Our ref: DOC22/738411-8

John Hunter Hospital Health and Innovation Precinct Project (SSD-9351535 MOD 2) – Vegetation Clearing

John Hunter Hospital Health and Innovation Precinct – Vegetation Clearing (SSD-9351535 MOD 2) – Review of the BDAR

Scale 1:10000 at A4

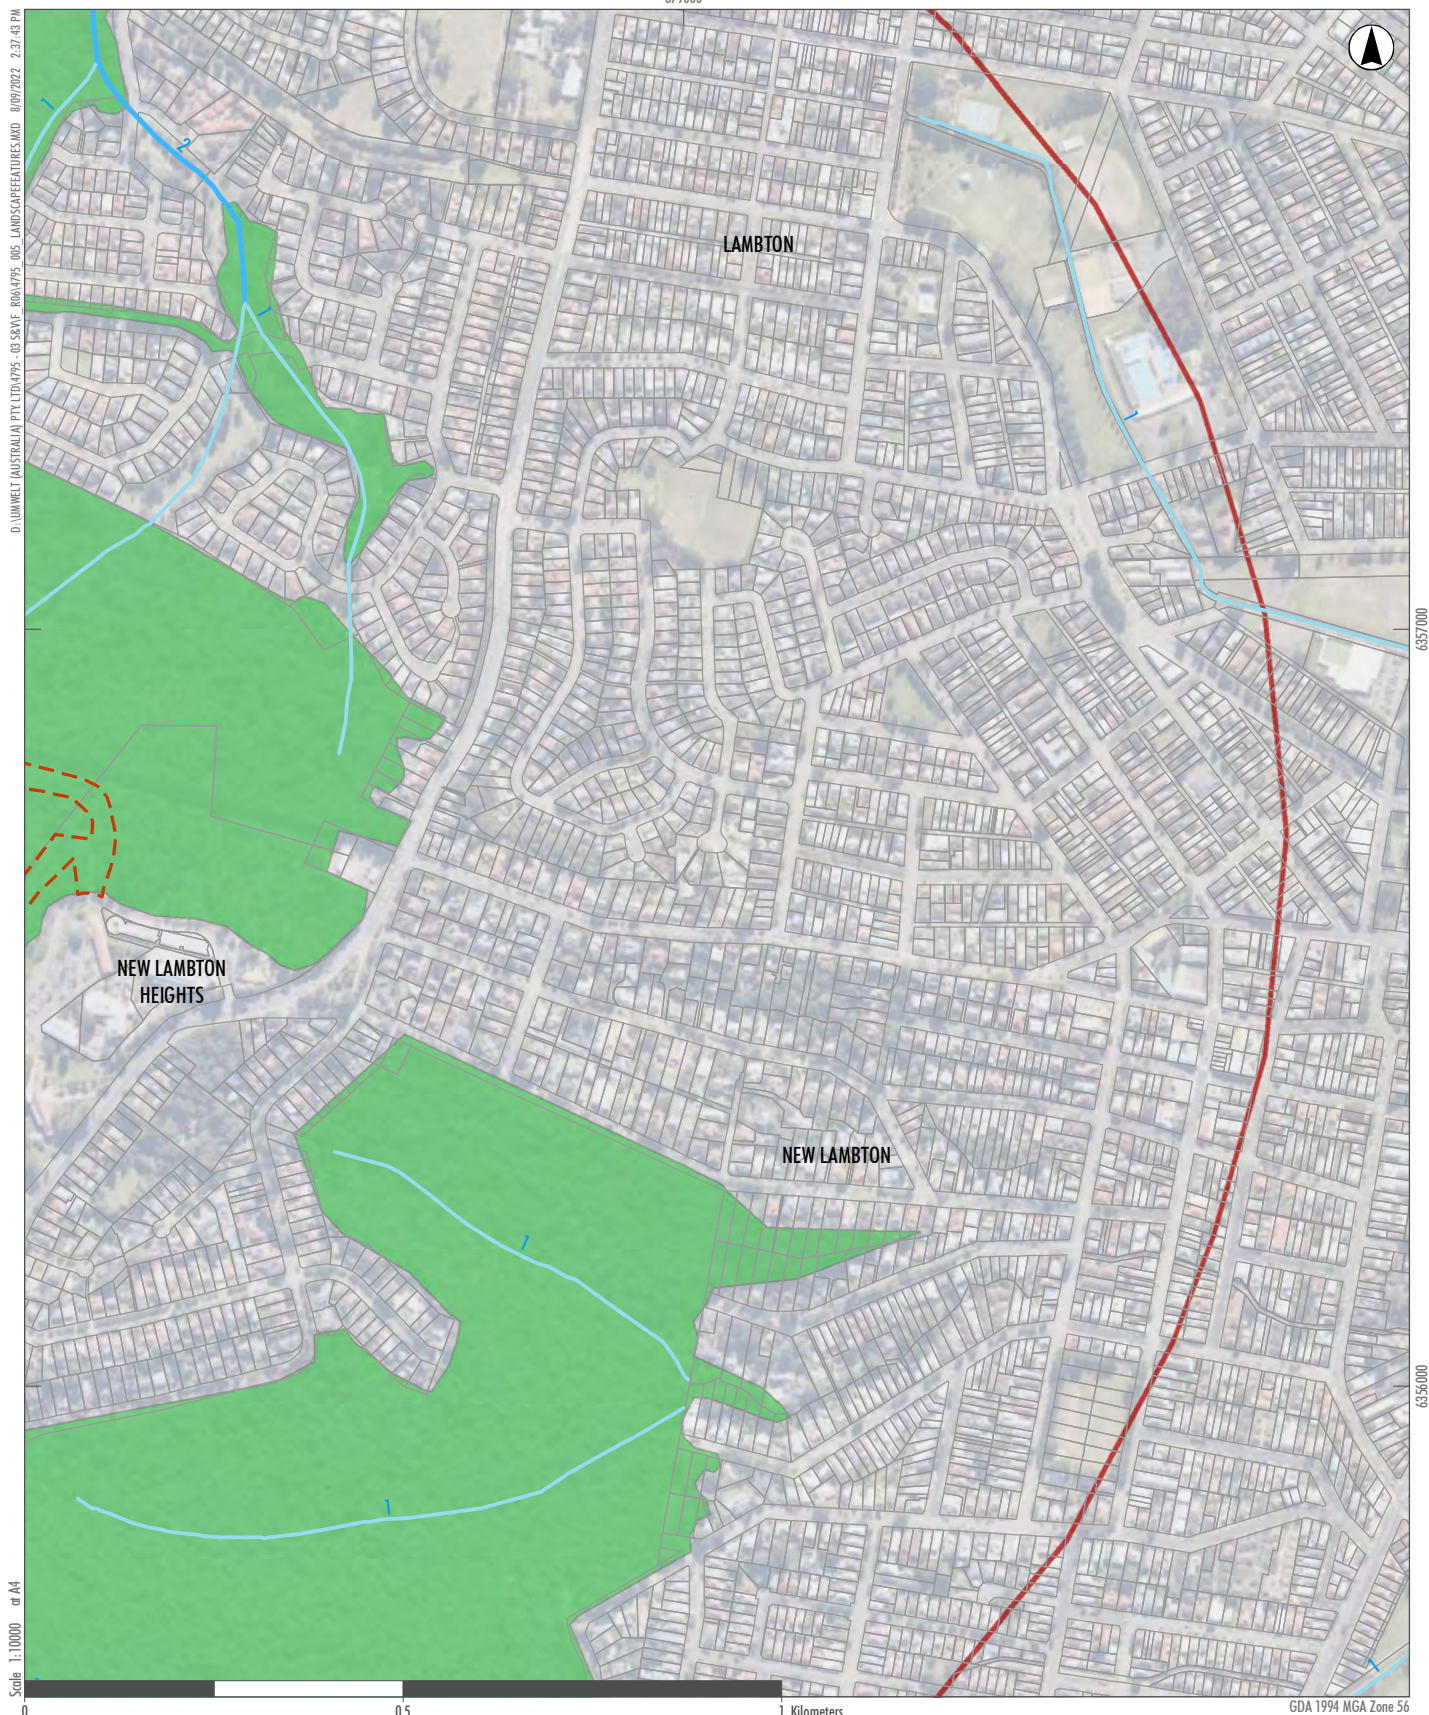
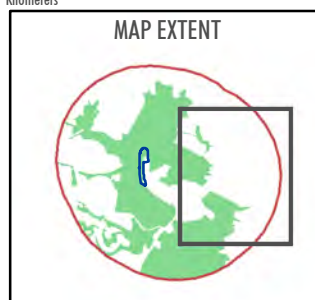
Figure 2.1 'Landscape Features' shows the mapped extent of native vegetation and is presented at a scale of 1: 24,000. However, Section 4.1 of the BAM 2020 requires that mapped native vegetation extent is presented at no more than 1:10,000, so that it is clearer for the

reader to see. BCD therefore recommends that either Figure 2.1 is redrawn to be at no more than 1:10,000 scale, or that a new map at no more than 1:10,000 is produced showing the extent of native vegetation.

BCD recommends a map showing the extent of native vegetation is provided that is at no more than 1:10,000 scale in order to meet requirements of the BAM 2020.

FIGURE 5.1

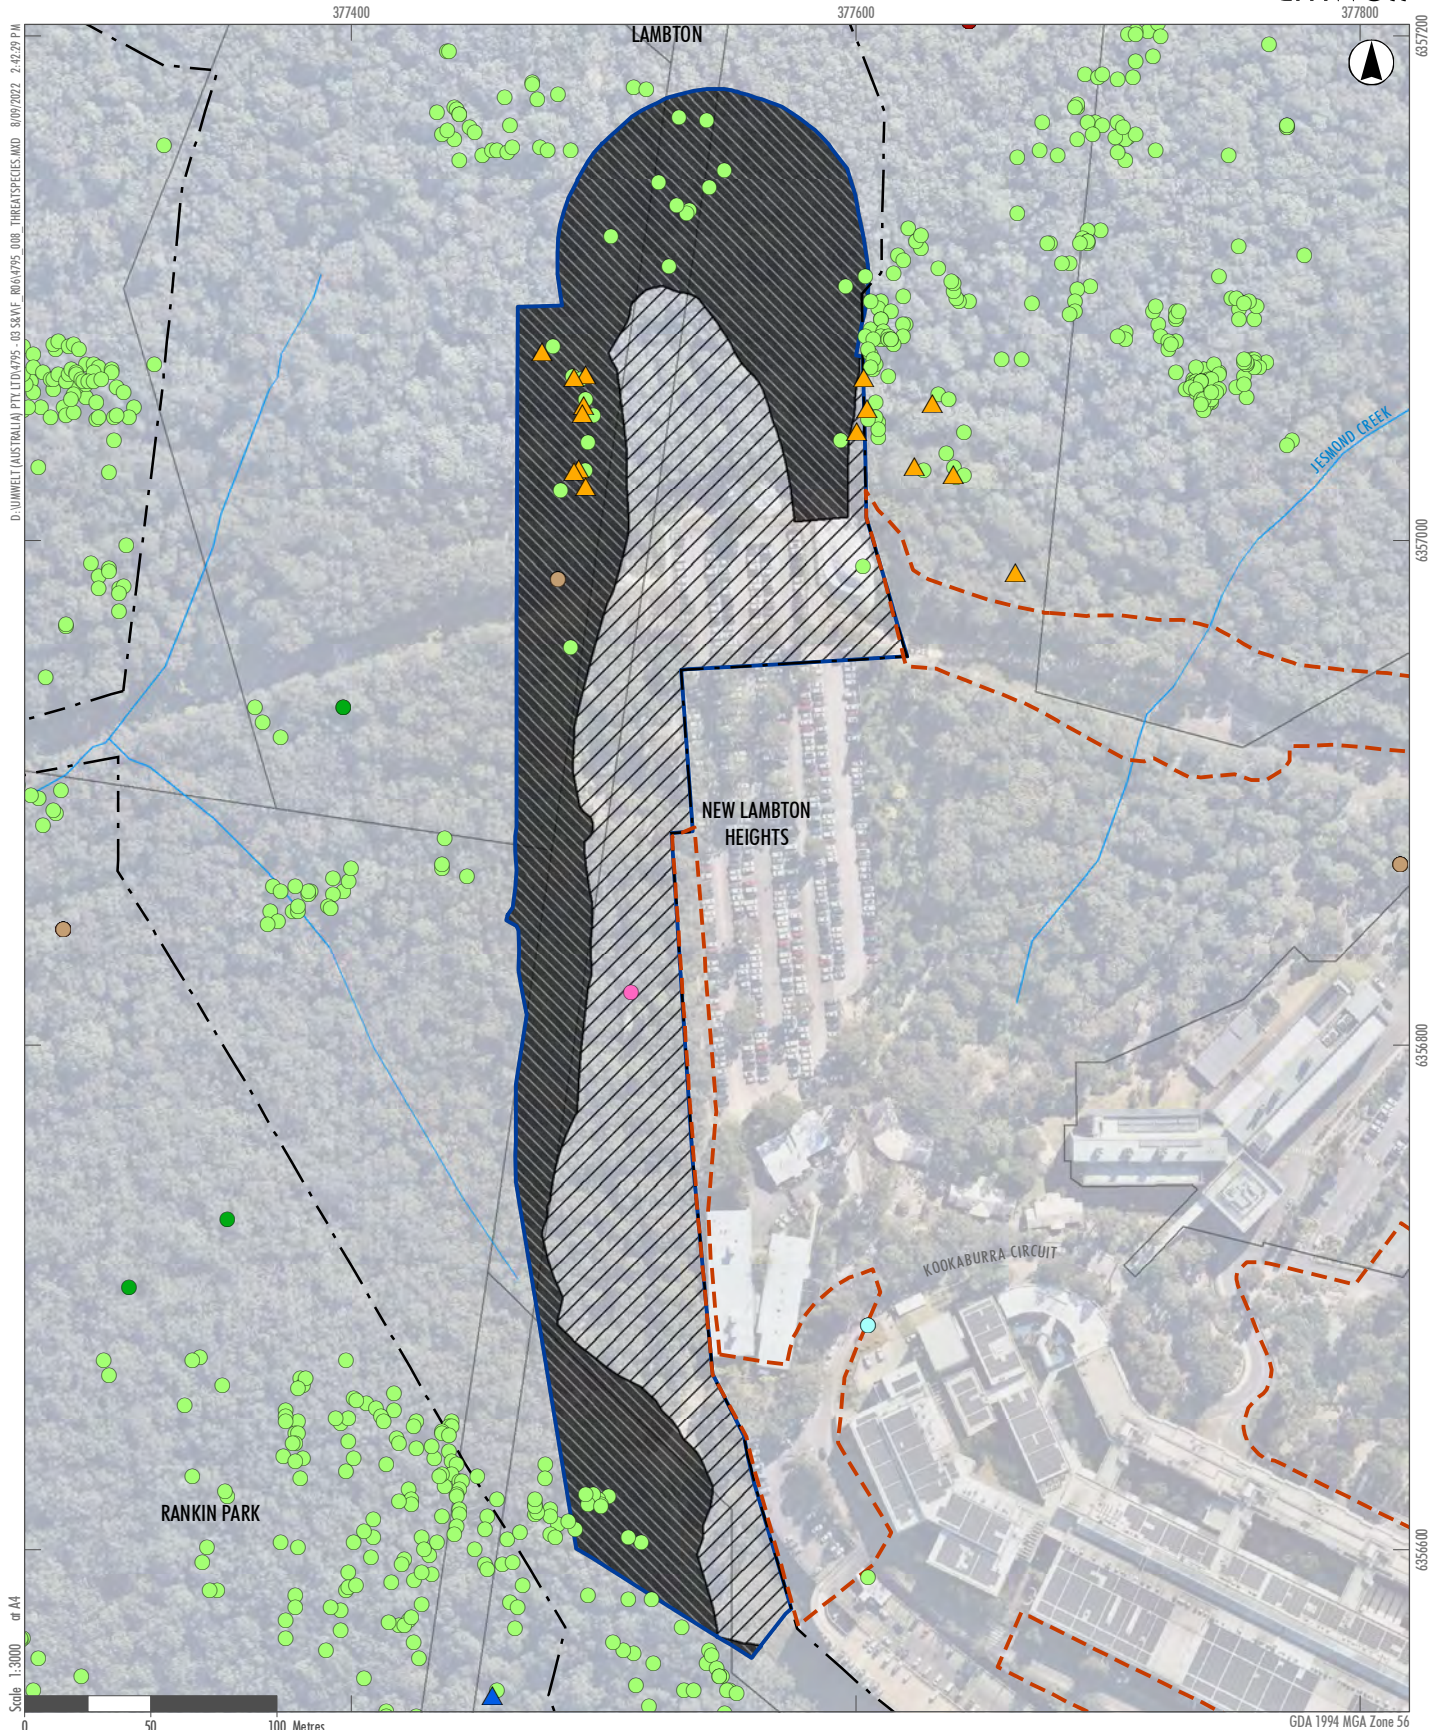
Section 5.2 'Results' in the BDAR does not indicate where the new local record of the *Corybas dowlingii* is in relation to the Subject Land. This detail could explain, along with the targeted surveys, why the species did not generate credits to be offset for this project. BCD recommends that Figure 5.2 'Threatened Species Records' is revised to show the approximate location of the new local record of the *Corybas dowlingii* in relation to the Subject Land and that Section 5.2 describes the site in relation to the Subject Land.

BCD recommends further details are provided of the new local record of *Corybas dowlingii* in relation to the Subject Land and what this means for the assessment.
